PORTLAND MAINE

June 5, 2007

RE: 795 Forest Avenue – 137 C003 – B2 – add outside deck – permit # 07-0583

Tax Map No. 137, Lot No. 3, Block No. C

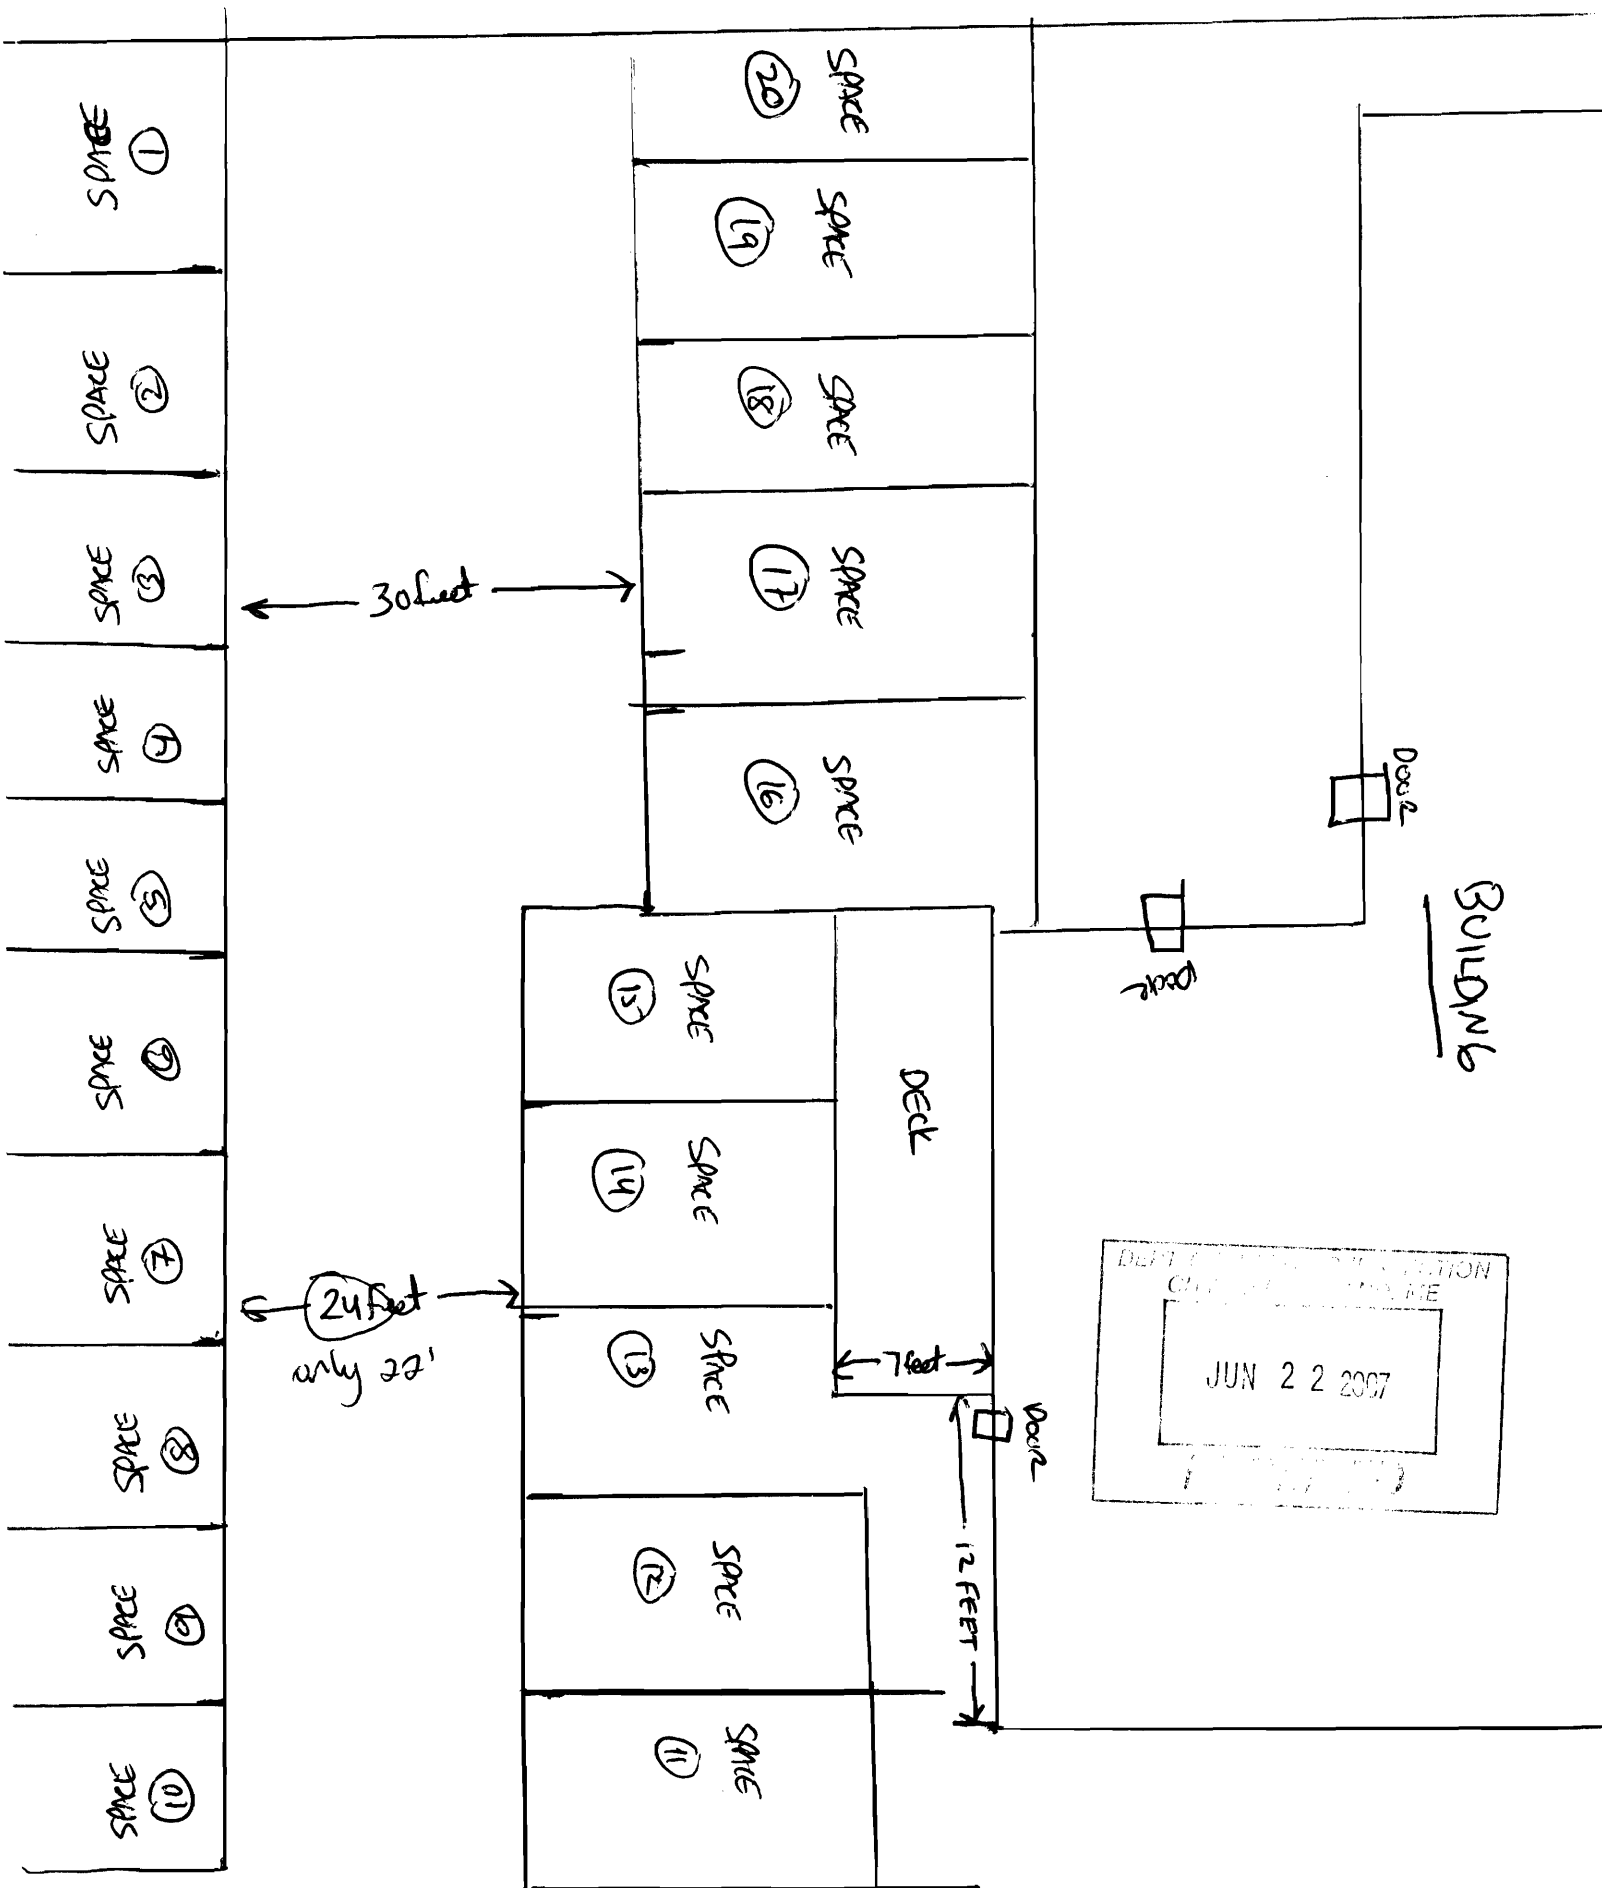
In reviewing your application to build a deck outside of your restaurant at 795 Forest Avenue, I found your application to be incomplete. The application lacked a plot plan showing the shape and dimension of the lot, the footprint of the existing and proposed structure and their distance from the actual property lines, and the location and dimensions of the parking area. Without this plot plan, I cannot determine if the deck meets the requirements of the underlying zone.

I called and left a message at the restaurant on May 29, 2007. Mike Corey called me on June 1, 2007, and I told him about the need for a plot plan. He brought in a partial plot plan yesterday showing the location of the deck, but the parking spaces were being relocated. This proposed parking change did not meet the parking standards in the City of Portland Technical and Design Standards and Guidelines. Mike Corey brought in another partial plan today with a new location for the deck. I told Mike that without a full site plan I couldn't determine if the newest proposal meets the underlying zone requirements. Your application for the deck is on hold until we receive a complete site plan.
